**KIRKLEES METROPOLITAN COUNCIL  
INVESTMENT & REGENERATION SERVICE**

**DELEGATED DECISION TO DETERMINE PLANNING APPLICATIONS**

Reference No:	<b>2023/62/93753/E</b>
Site Address:	371, Halifax Road, Hightown, Liversedge, WF15 8DU
Description:	Alterations and extension to outbuilding to create dwelling forming ancillary annex and erection of first floor extensions to front and rear to existing dwelling, front and rear dormers, alterations to roof to form gable ends and erection of detached garage
Recommending Officer:	Elenya Jackson

## **OFFICER REPORT: 2023/93189**

Client		Mr & Mrs Pitman	
Job		371 Halifax Road Liversedge	
Title		Proposed Annex Floor and Elevation	
Drawn By	RK	Date	Nov 2023
Eng. Check		Scale	1:50,100
Tech. Check			
Drawing No.		2023 / 436 / 07	
		Rev.

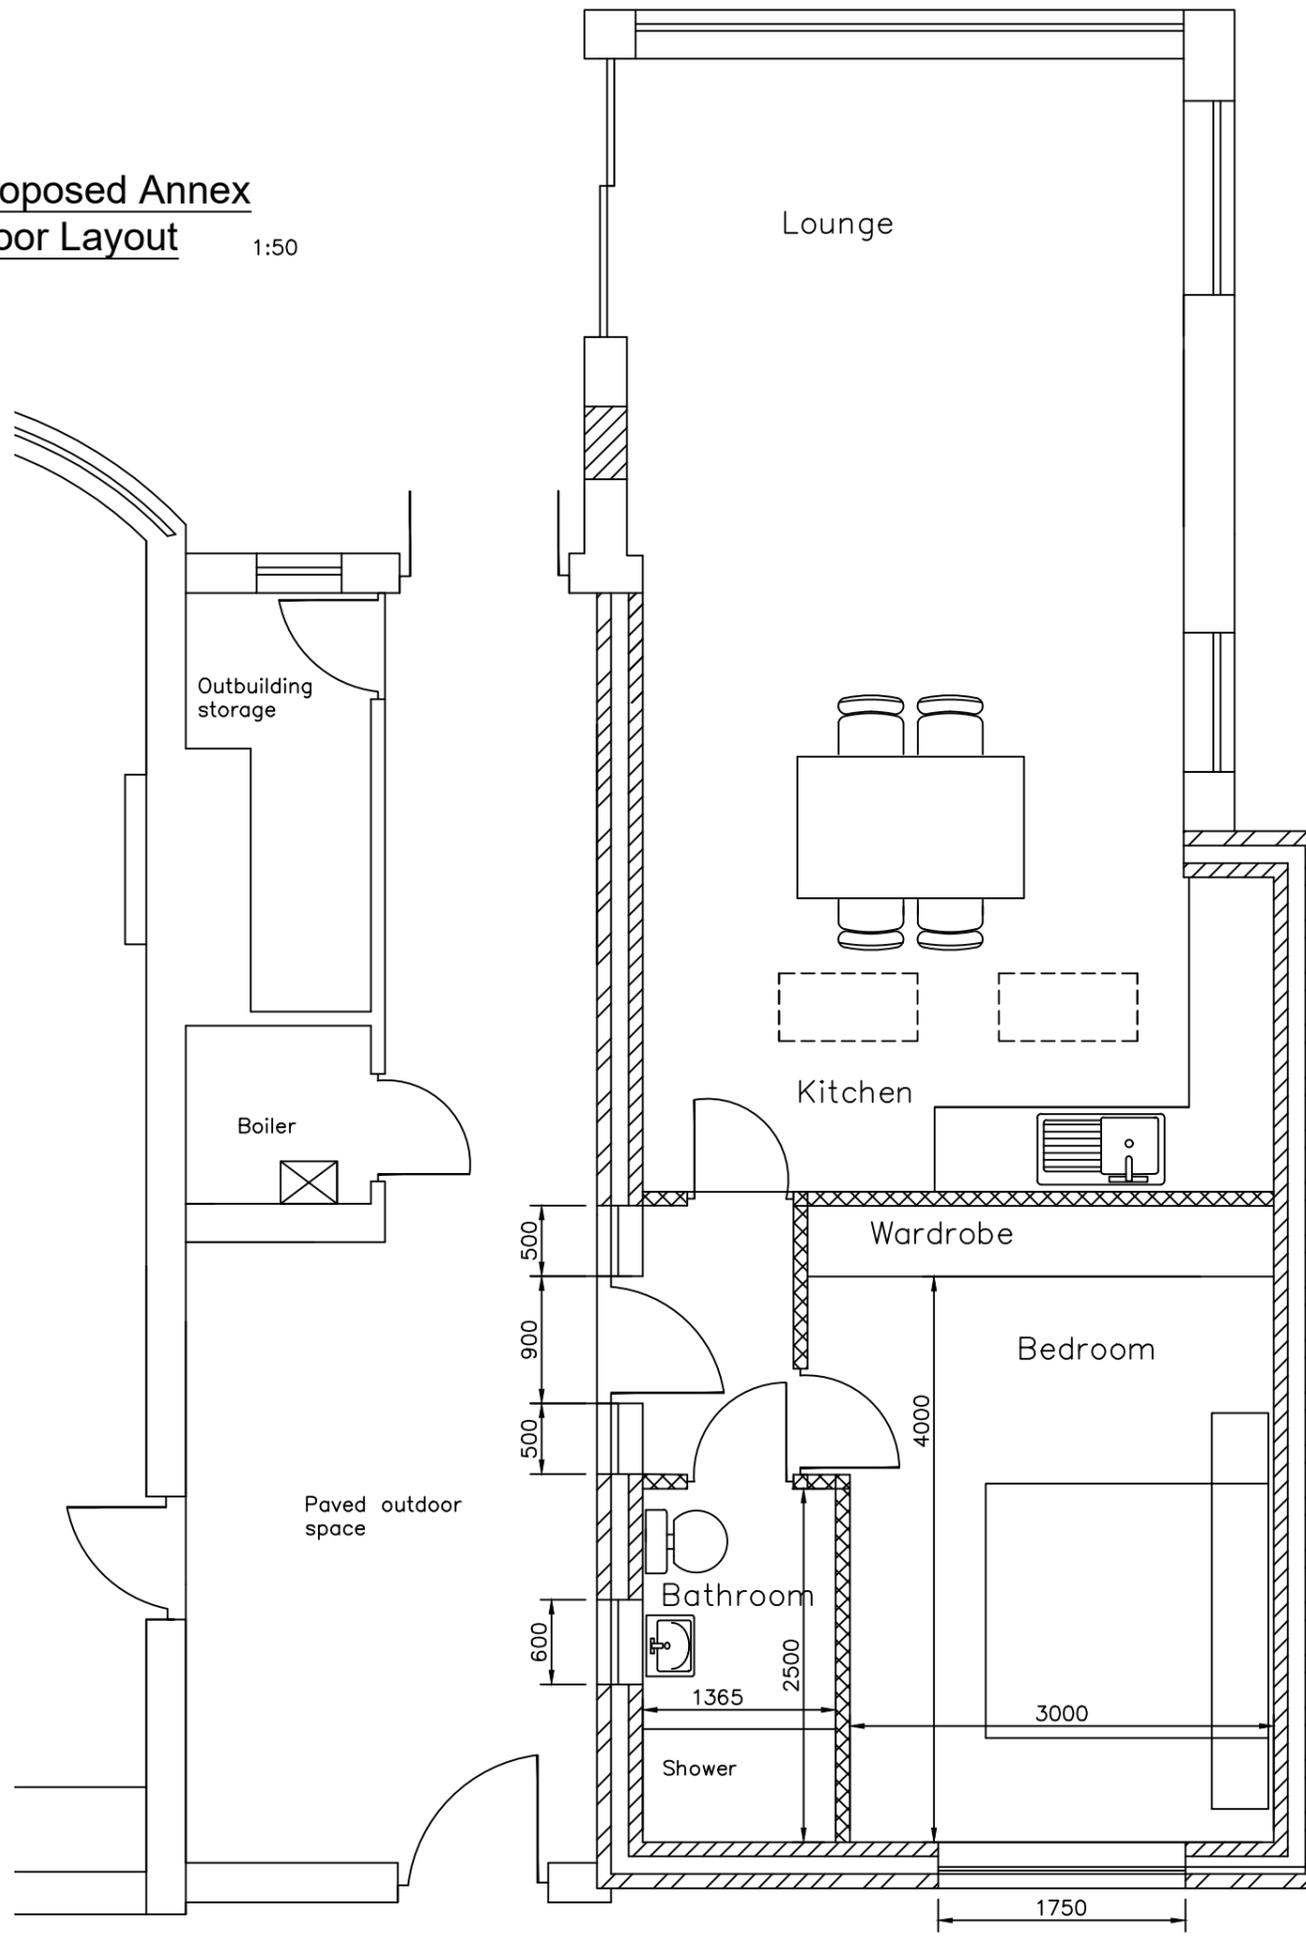
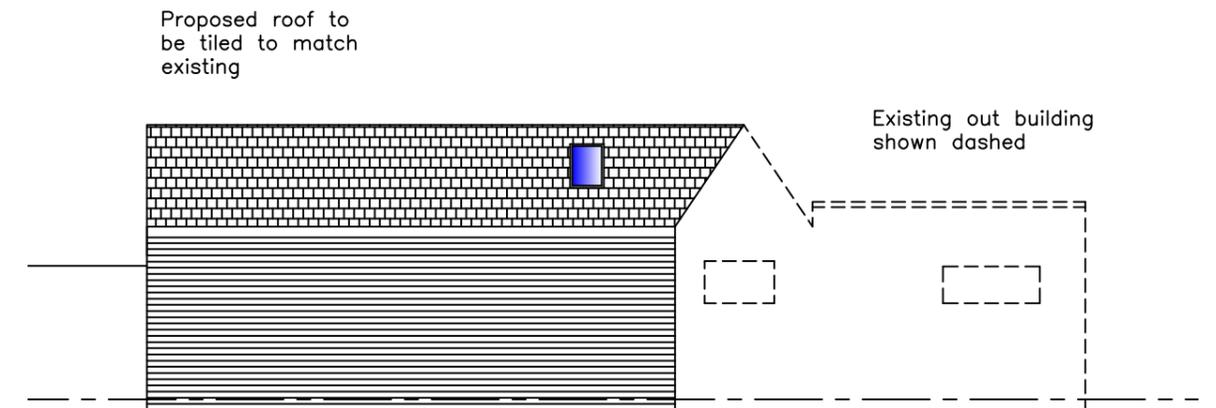
**Response:** This would not be brought any closer than existing development.

Client		Mr & Mrs Pitman	
Job		371 Halifax Road Liversedge	
Title		Proposed Front & Rear Elevations	
Drawn By	RK	Date	Nov 2023
Eng. Check		Scale	1:100
Tech. Check			
Drawing No.		Rev.	
2023 / 436 / 03

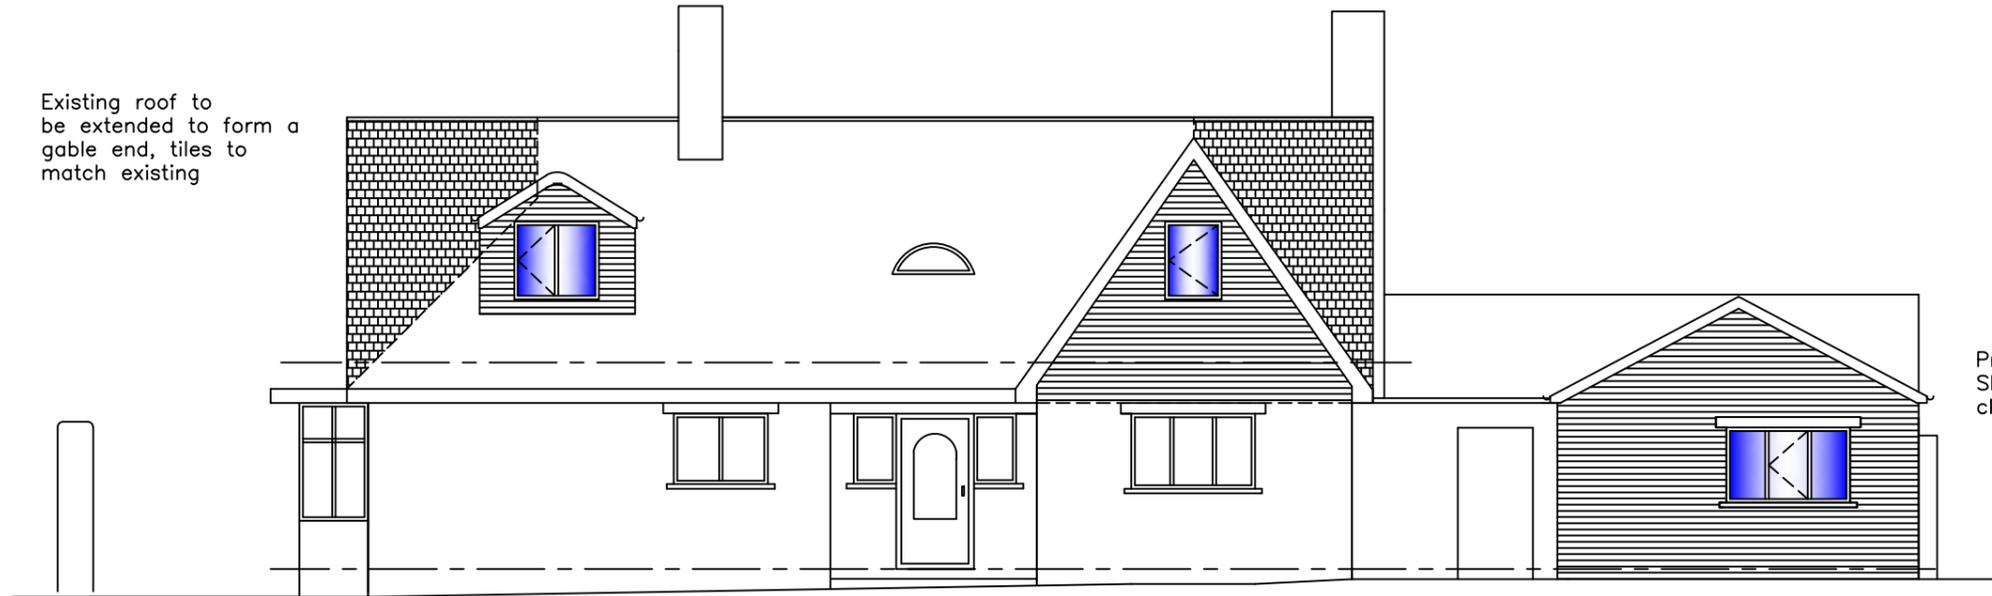
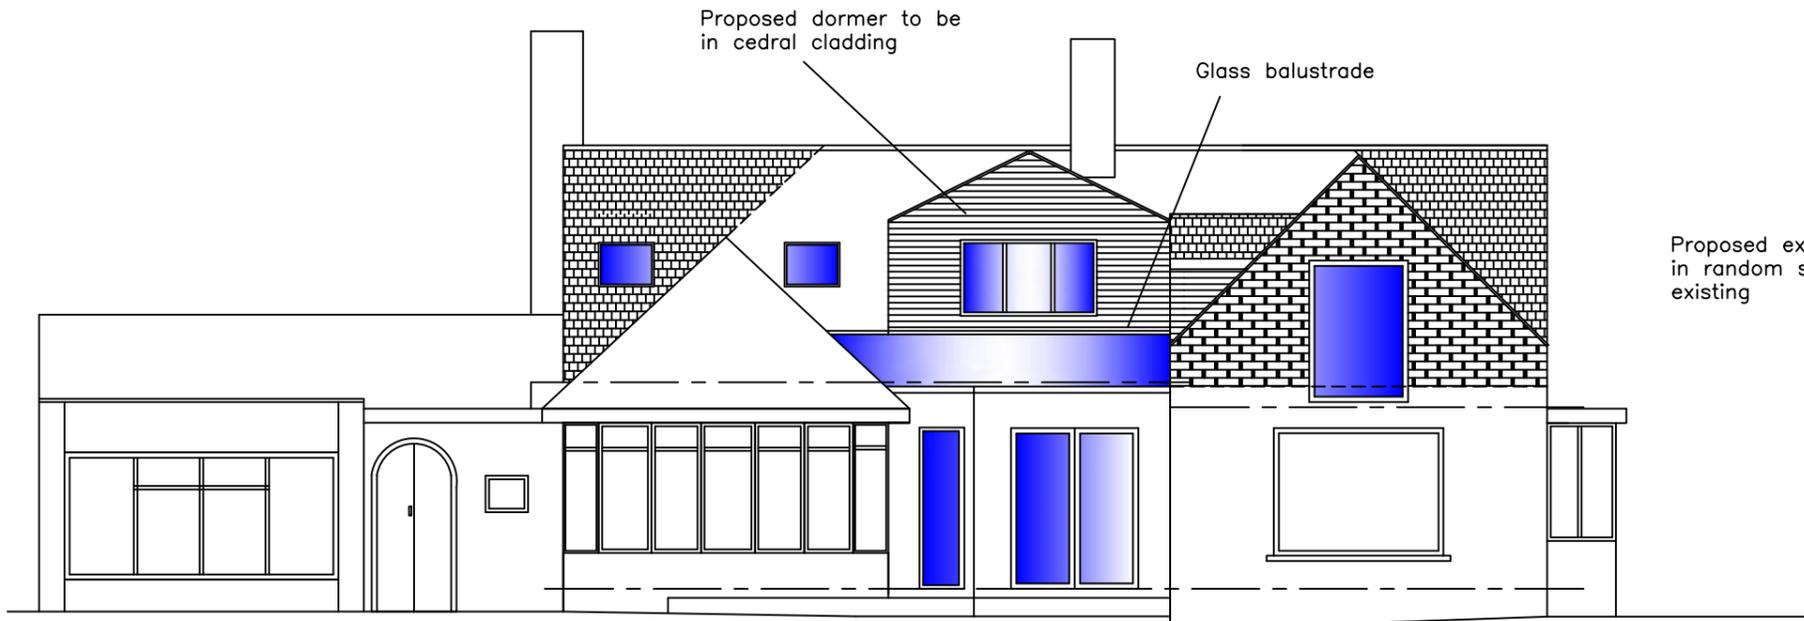
The dormer on the principal elevation of the dwelling would have a height of 2.1m and a width of 2.2m.

The existing projection on the front of the dwelling would increase to have a maximum height of 6.2m with a front gable.

The alterations to the rear would include a first floor extension above the existing projection, the introduction of a rear dormer and a balcony.

The rear dormer would have a width of 3.9m with a height of 3.2m. This would have a cedar cladded finish.

The extension above the existing projection would increase the height of the projection to 6.6m and feature a pitched roof.

The balcony would be located above the existing dining roof and be enclosed with a glass balustrade.

The rear dormer would be of substantial scale, however, this would not be highly prominent within the street scene and subservient in the roof space.

The dormers would feature a cedar clad finish. It is considered that as the area does not have a uniform appearance, the use of cedar cladding would be a contemporary addition in this instance and officers would recommend a condition of samples to ensure an appropriate colour was used.

The rear dormer and balcony are centrally located and part screened by the proposed extension. Taking into account its location and design it is not considered to result in any materially greater overlooking of neighbouring gardens when taking in to account the existing relationships in the area. There are first floor windows similarly positioned that currently have views. The setting back of the balcony helps to mitigate any impact. This element of the proposed development is considered acceptable and would not result in a reduction in amenity to the extent the application should be refused.

3. Notwithstanding the plans submitted, details of the external walls and roofing materials shall be submitted and approved in writing by the Local Planning Authority. The materials of construction shall thereafter be retained for the lifetime of the development.

Client		Mr & Mrs Pitman	
Job		371 Halifax Road Liversedge	
Title		Proposed Garage & Site Plan	
Drawn By	RK	Date	Nov 2023
Eng. Check		Scale	1:50
Tech. Check			
Drawing No.		2023 / 436 / 05	
		Rev.

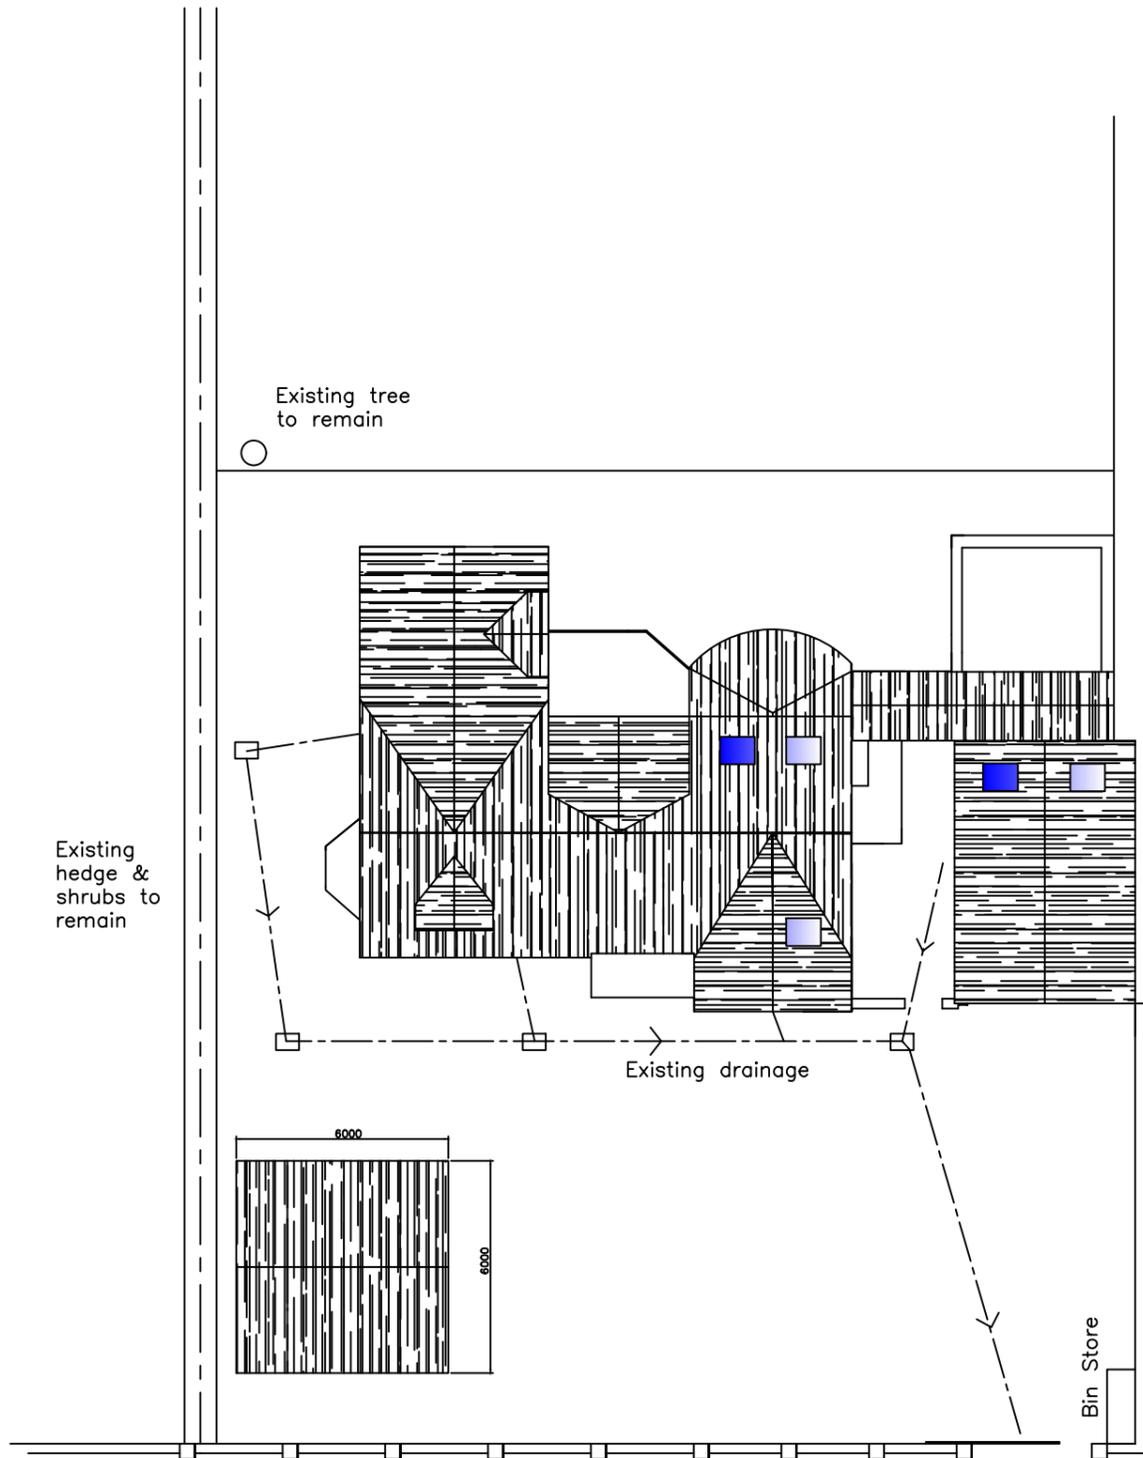
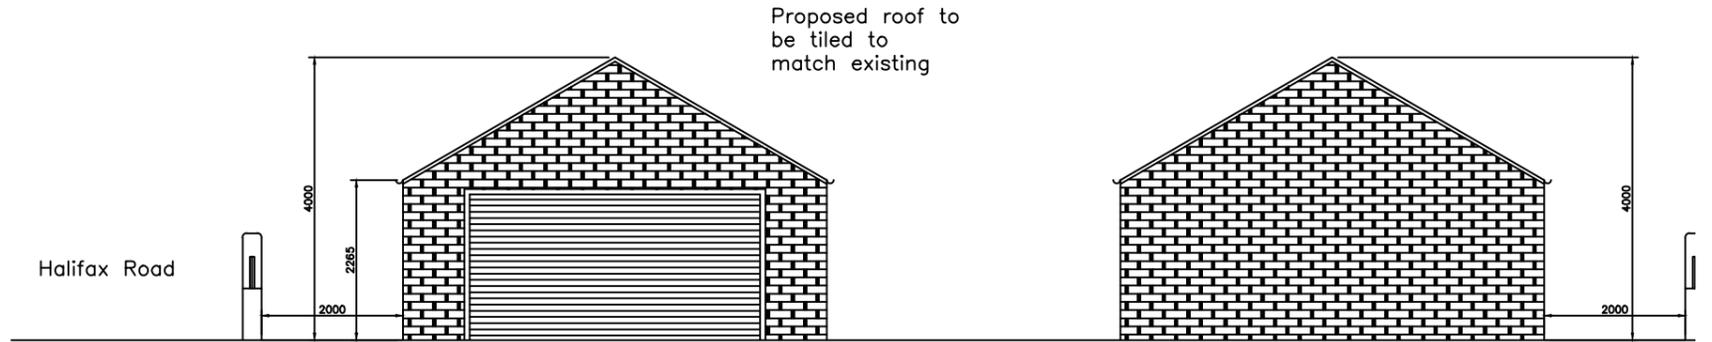
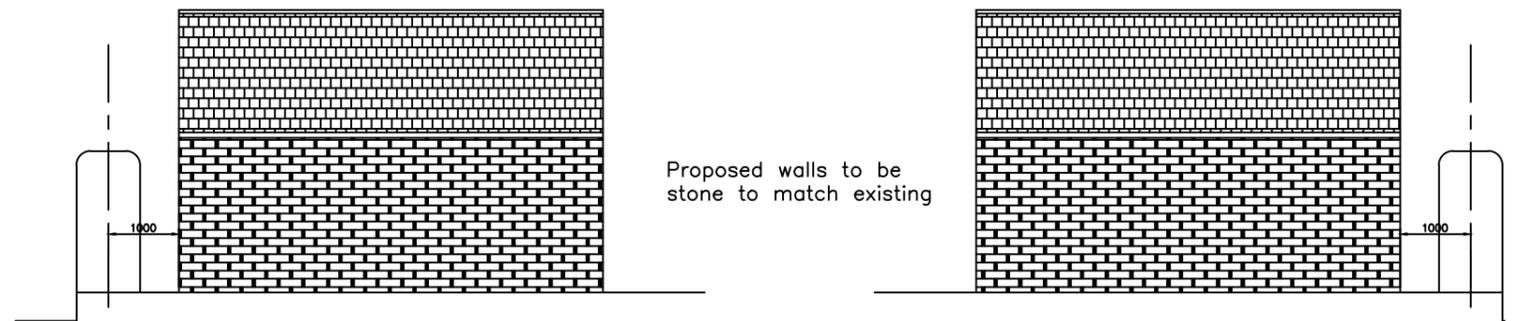
The proposed garage would have a width of 6m and a depth of 6m with a maximum height of 4m.

It is acknowledged that the garage would be located to the principle elevation of the dwelling and it has previously been stated that the dwellings in the street scene follow a reasonably consistent building line. Despite this, there are other examples of outbuildings to the front of dwellings to the west of the application property and the main dwelling would still be prominent within the plot.

The proposals would result in the intensification of the domestic use of the site due to it creating three upstairs bedrooms. The site currently has a driveway and the garage would retain 2 parking spaces and the site does have additional space should further parking be required. The proposal is considered to comply with Policy LP22 of the Kirklees Local Plan along with Key Design Principles 15 & 16 of the House Extensions & Alterations SPD.

Client		Mr & Mrs Pitman	
Job		371 Halifax Road Liversedge	
Title		Proposed Side Elevations	
Drawn By	RK	Date	Nov 2023
Eng. Check		Scale	1:100
Tech. Check			
Drawing No.		Rev.	
2023 / 436 / 04

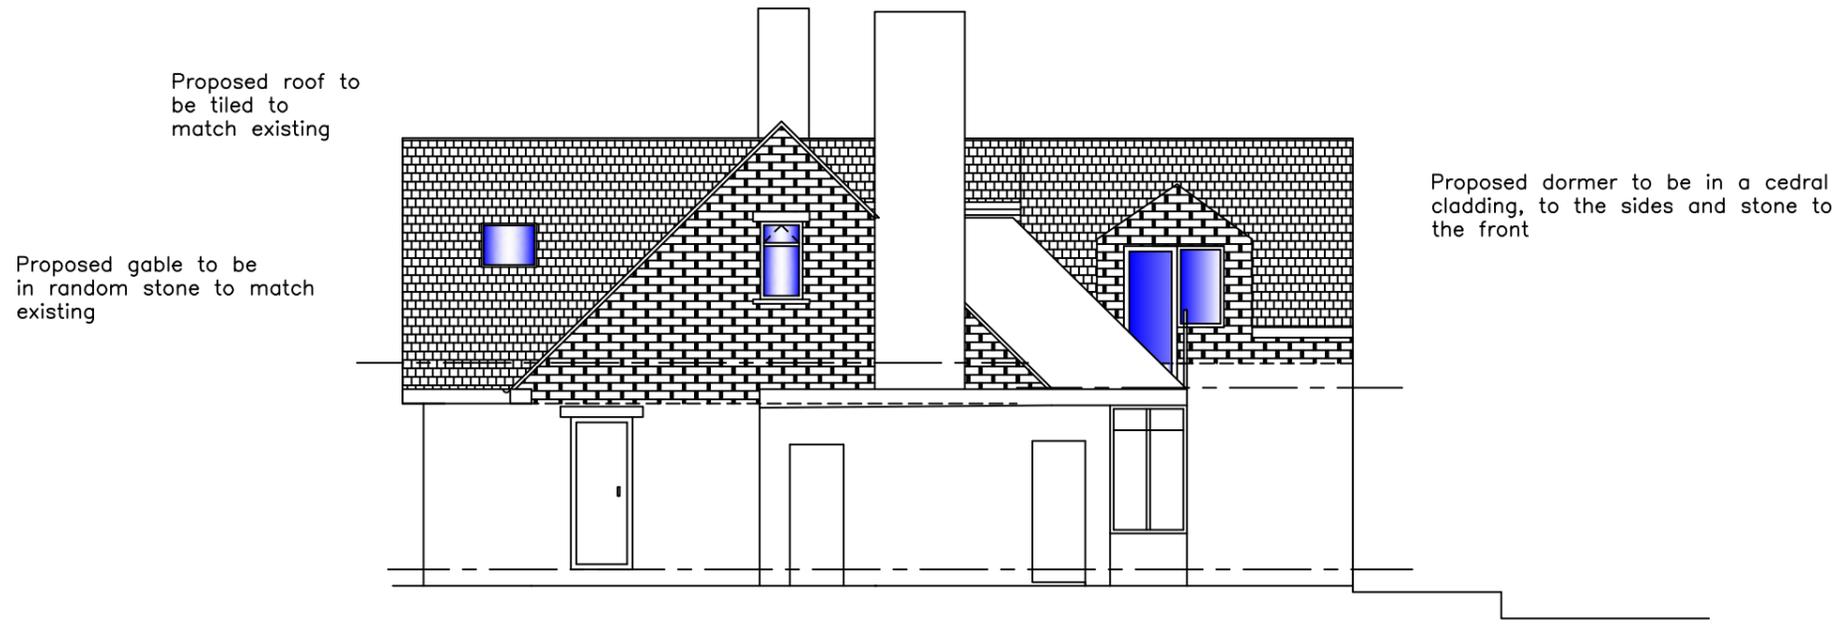
The proposed hip to gable alteration would extend 2.7m on the eastern elevation and 2.7m on the western elevation. This would not extend beyond the side elevation of the existing dwelling or above the ridge of the host property.

Overlooking: The proposal would feature side facing windows relating to a bathroom. It is considered this could be conditioned to be obscured and therefore no significant issues would arise regarding overlooking.

Overlooking: The proposal would feature three side facing windows. There would be 20.4m between the balcony door and the side elevation of no. 371a and 15m between the shared boundary of the dwellings. There is one side facing window at no 371A which would be in line with the host dwelling and there would not be a direct relationship between the window and the rear amenity space of no 371A. The other side facing windows would serve a bathroom and be a secondary velux window; Therefore, these would be conditioned to be obscured.

4. Notwithstanding the approved plans, prior to occupation of the development hereby approved, the first floor side facing window of the development shall be fitted with obscured glazing with a Pilkington level of four or equivalent. The window shall be retained as such for the lifetime of the development.

5. Notwithstanding the approved plans, prior to the occupation of the development hereby approved, the side facing bathroom windows in the eastern and western elevations shall be fitted with obscured glazing with a Pilkington level of four or equivalent. The windows shall be retained as such for the lifetime of the development.
